Briefing Note

Our ref 64194/06/MS/OW
Date 4 June 2025
To Planning Inspectorate
From Oxford Aviation Services Limited

Subject **Deadline D1 – Further Written Statement**

- 1.1 This Statement has been prepared on behalf of Oxford Aviation Services Limited (“OASL”), the operators of London Oxford Airport (“the Airport”), in response to the Rule 8 letter received concerning the application by Photovolt Development Partners (“PVDP”) for an Order Granting Development Consent for the Botley West Solar Farm project.

**Legend**

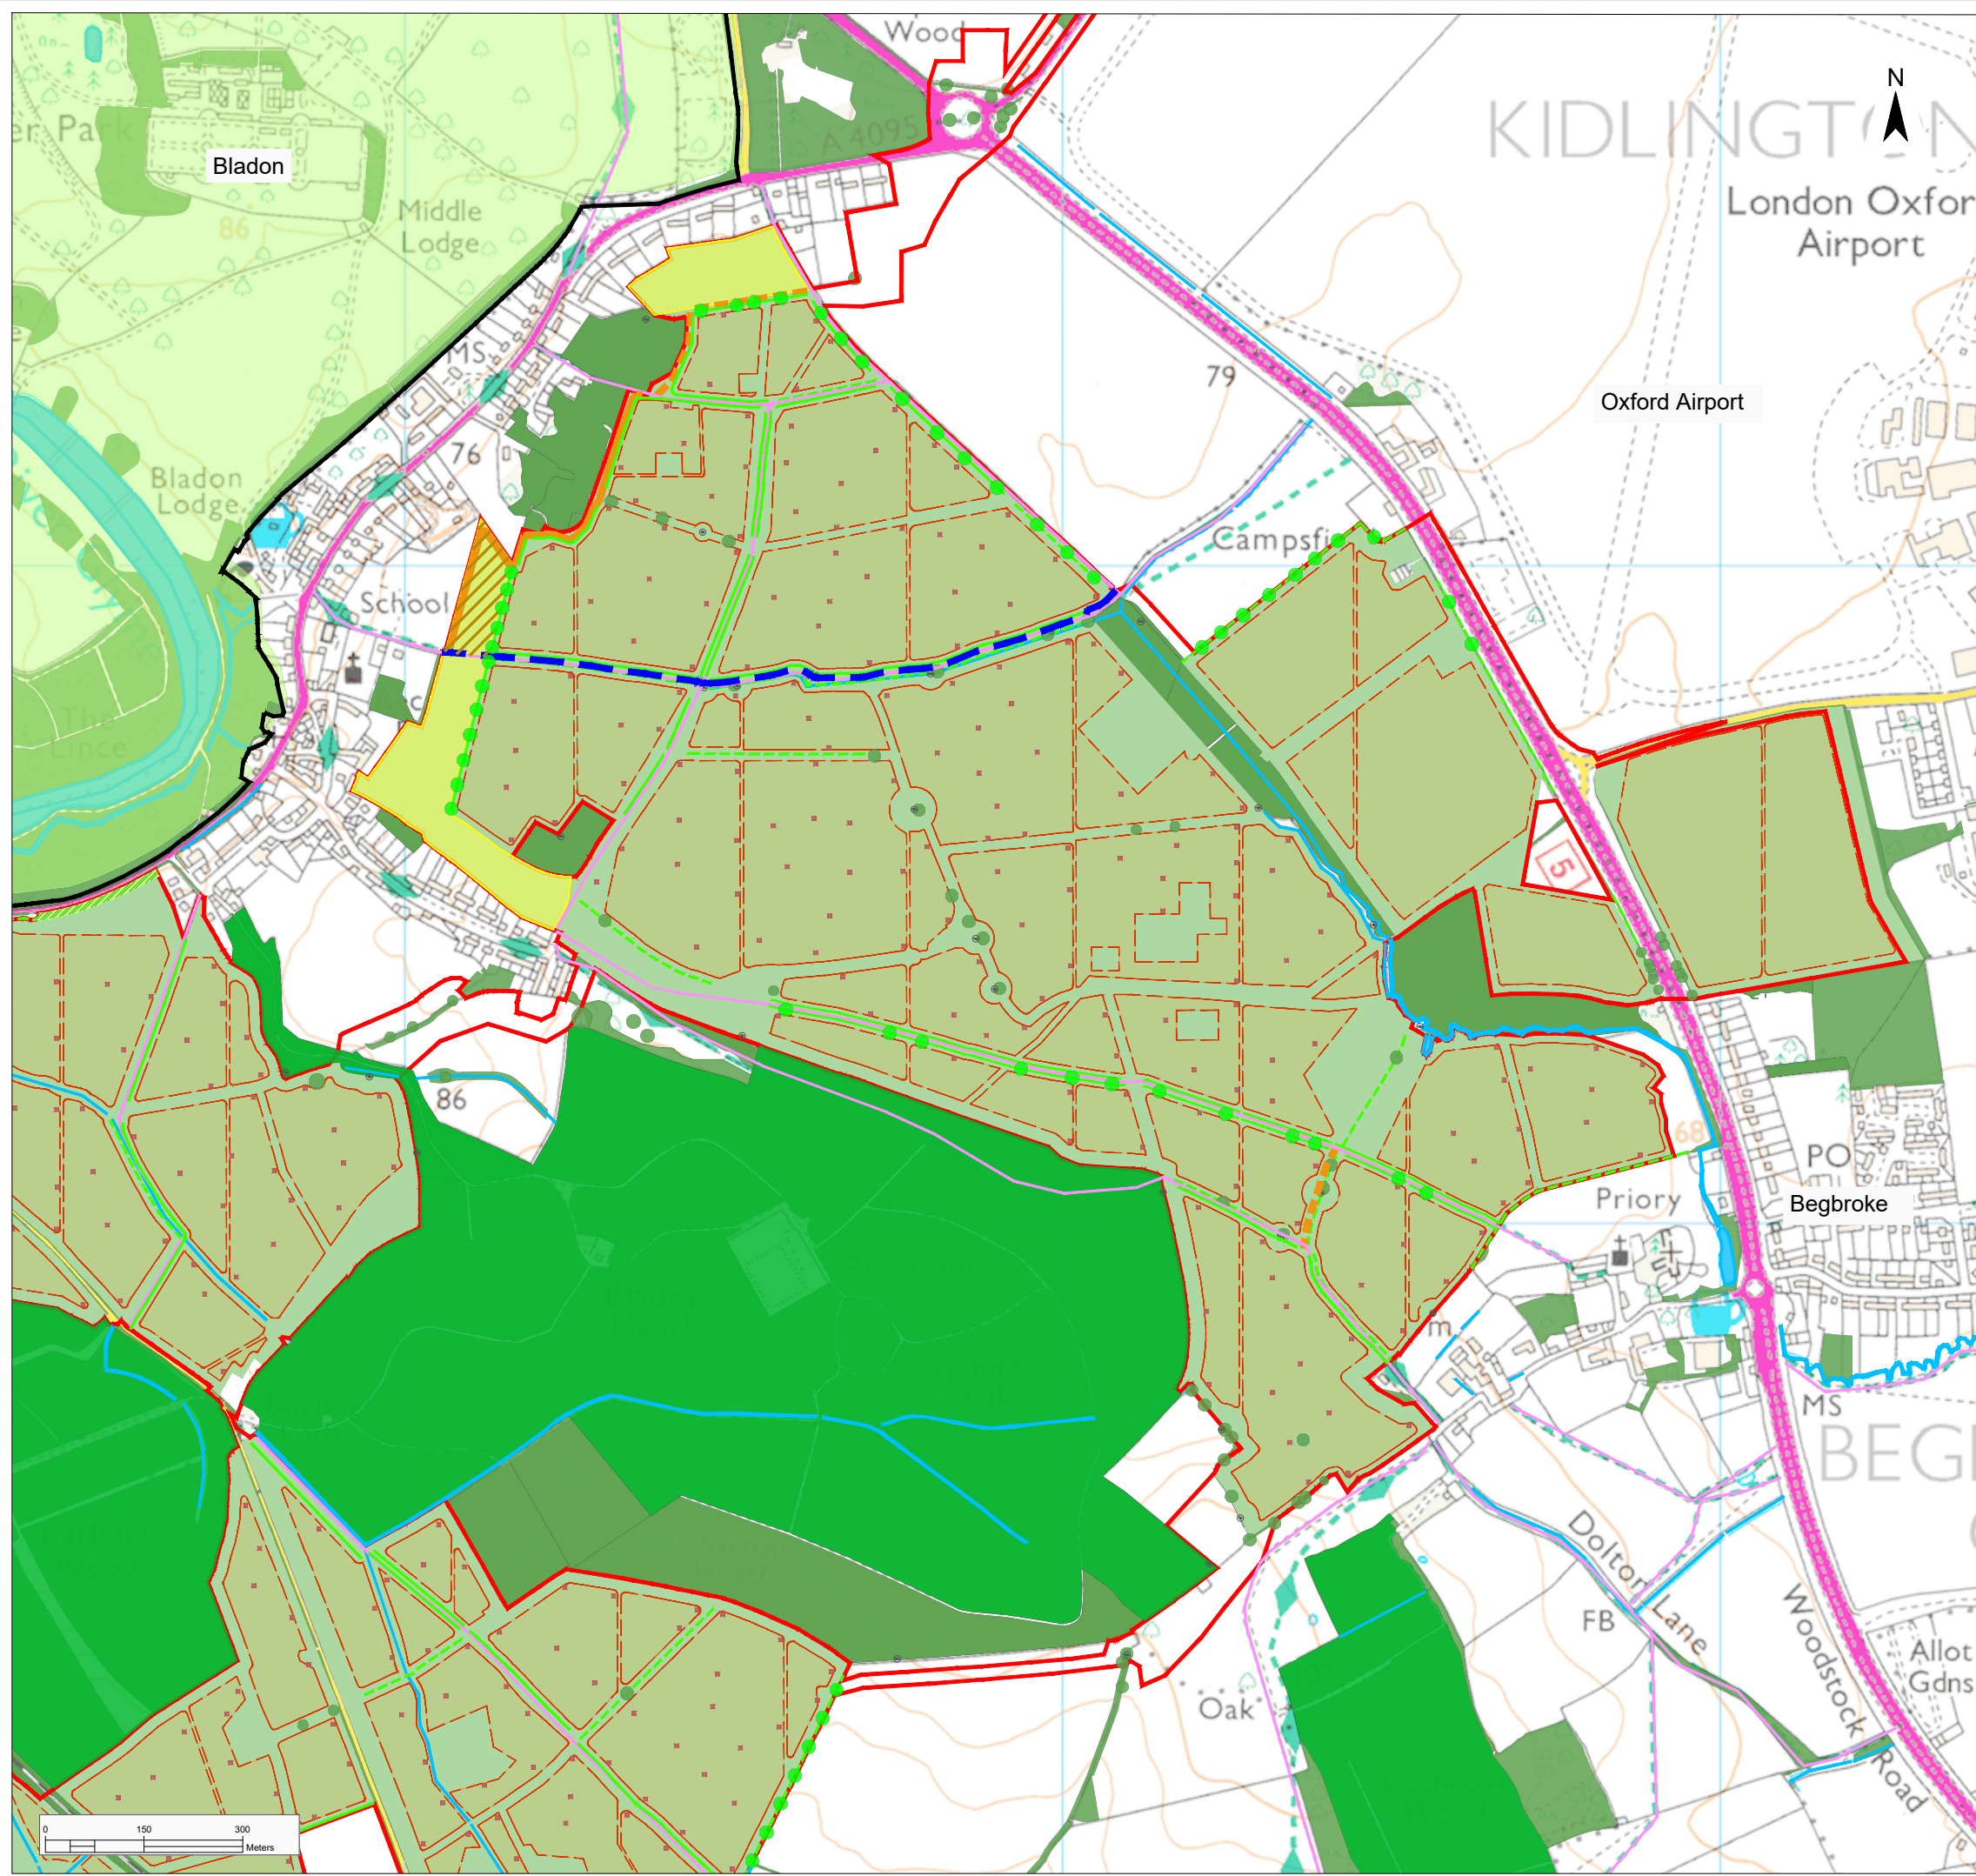
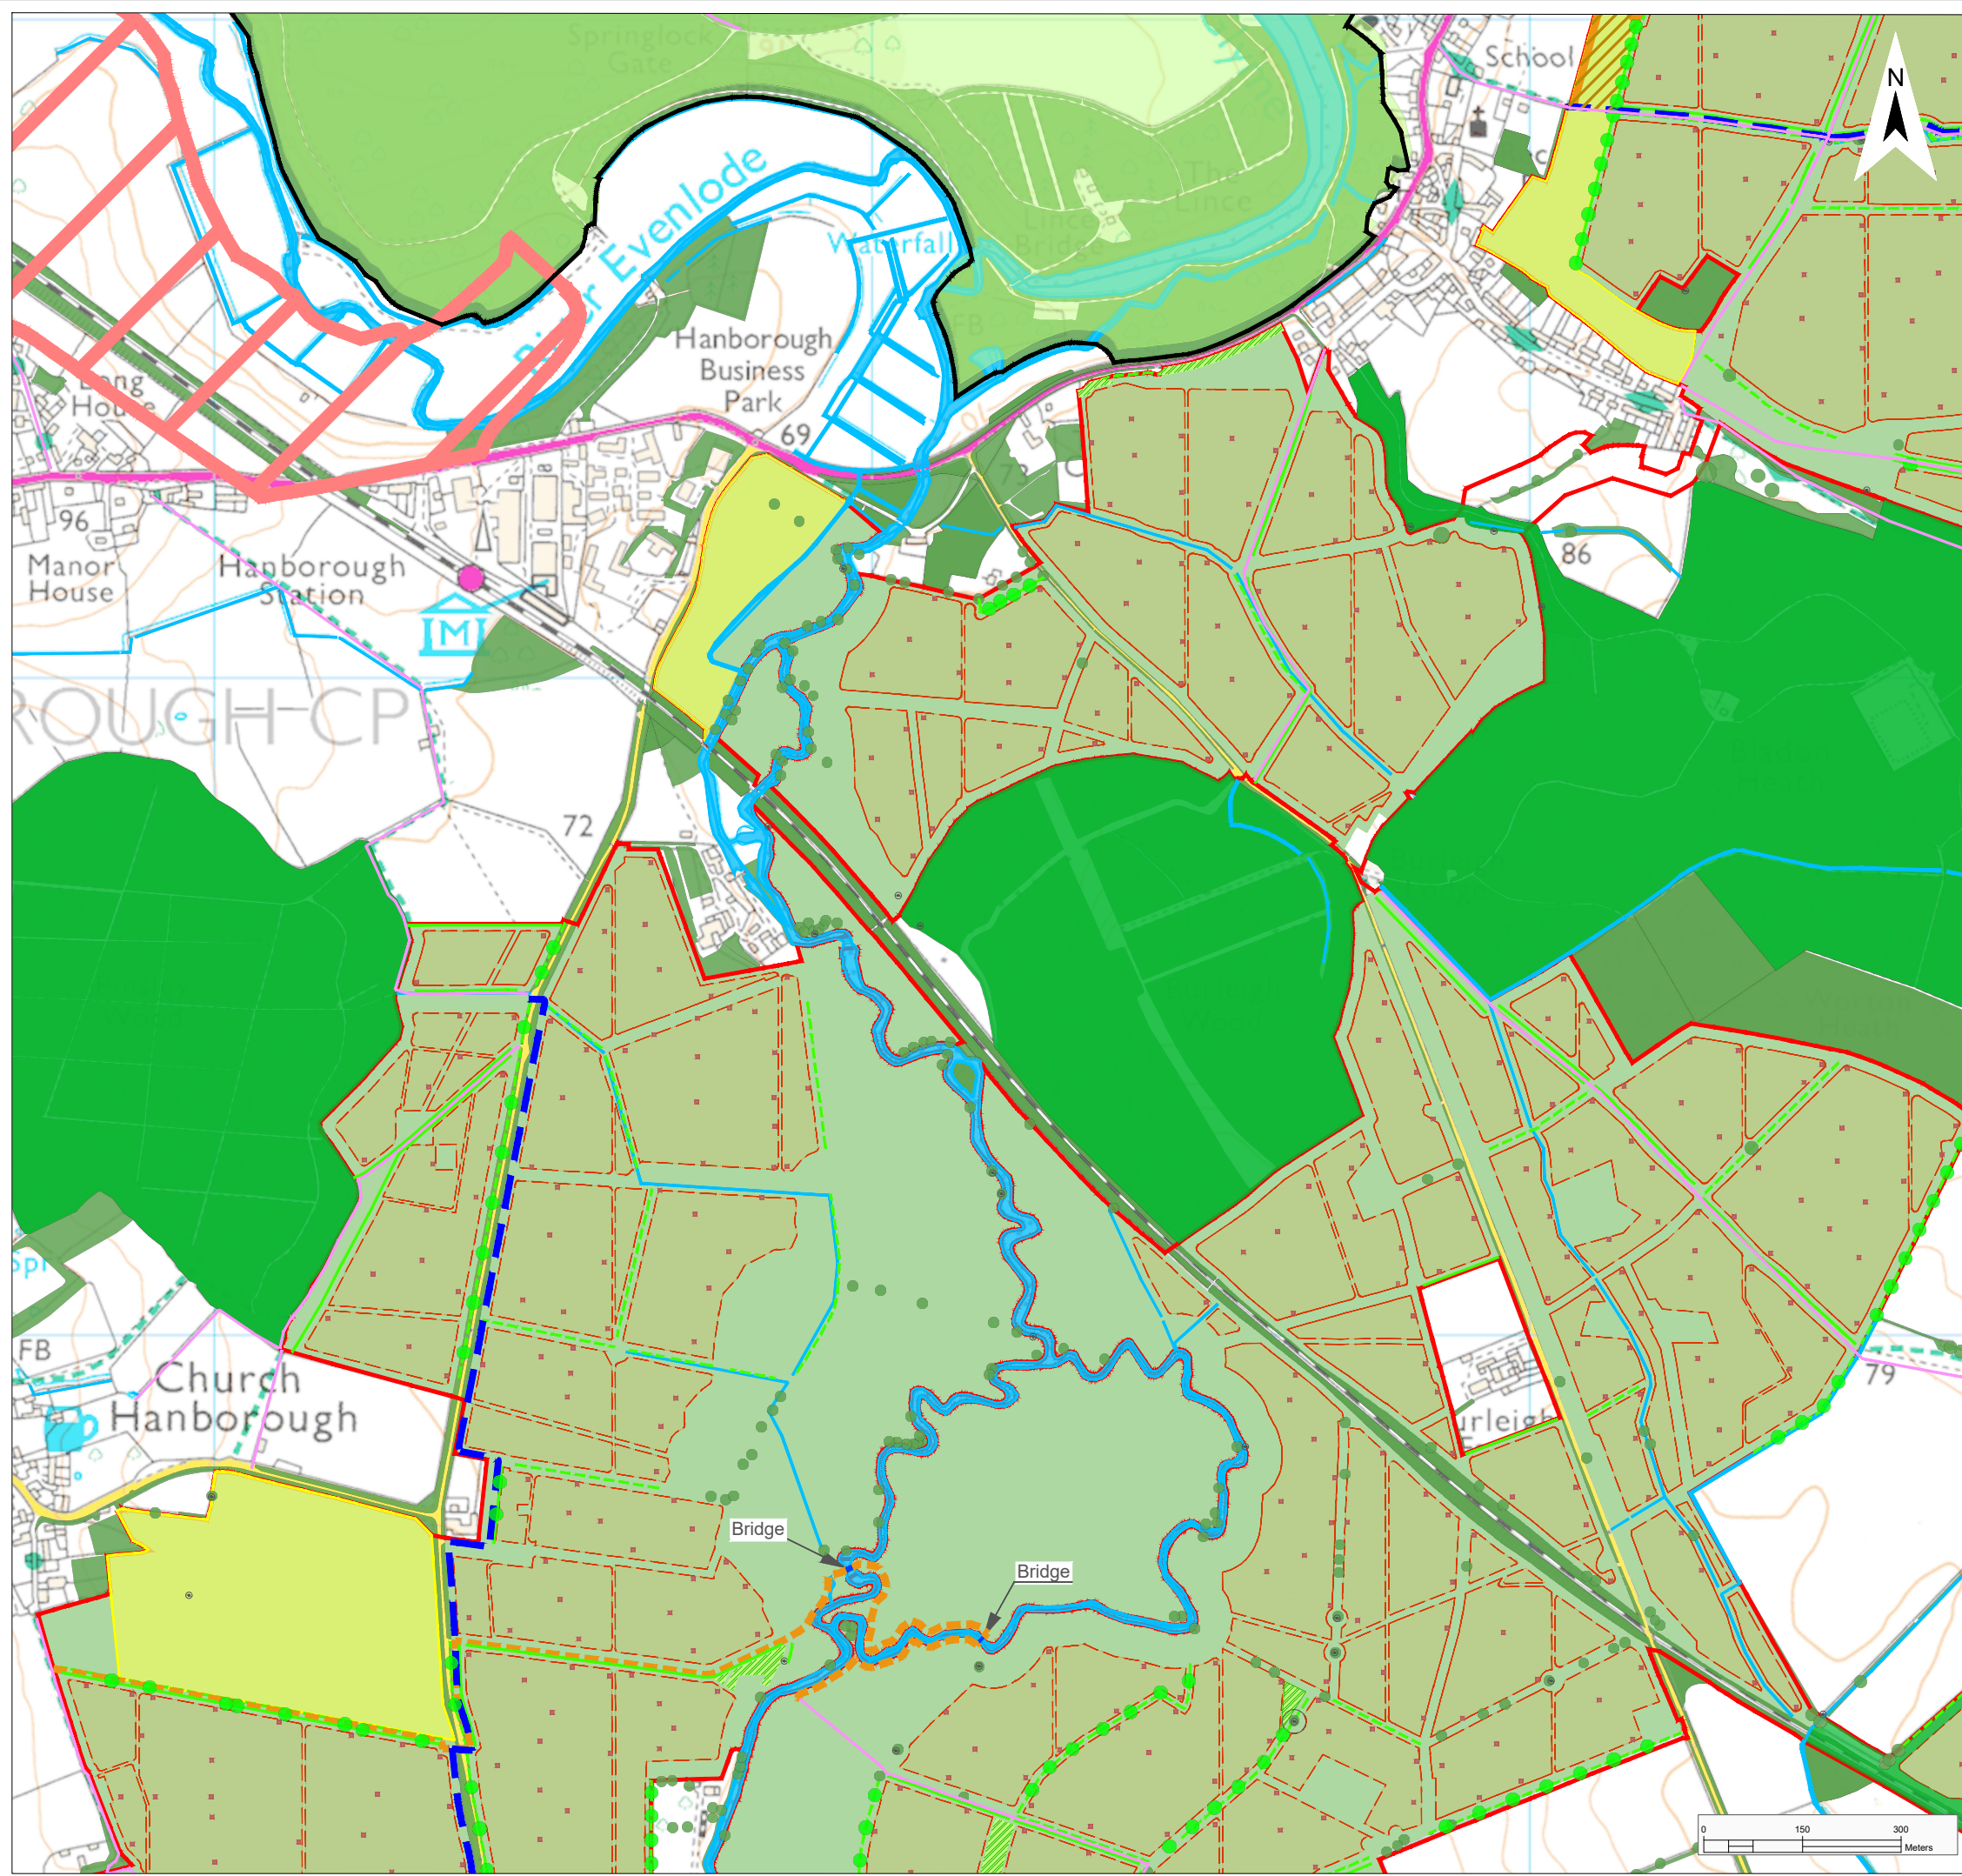
- 2.9 PVDP acknowledged that the submission documents had not considered the impact(s) of changing ecological activity around the Airport as a result of the development. It has agreed to review the proposals with a view to reducing zones of Green Infrastructure in areas around the Airport that might attract birds. They also agreed to consider other mitigations that could be introduced to assist the Airport in managing any increase in animal activity at the Airport as a result of the development.
- 2.10 PVDP agreed to present revised proposals to the Airport for review and agreement prior to submitting a proposed Change Order to the Inspectors.
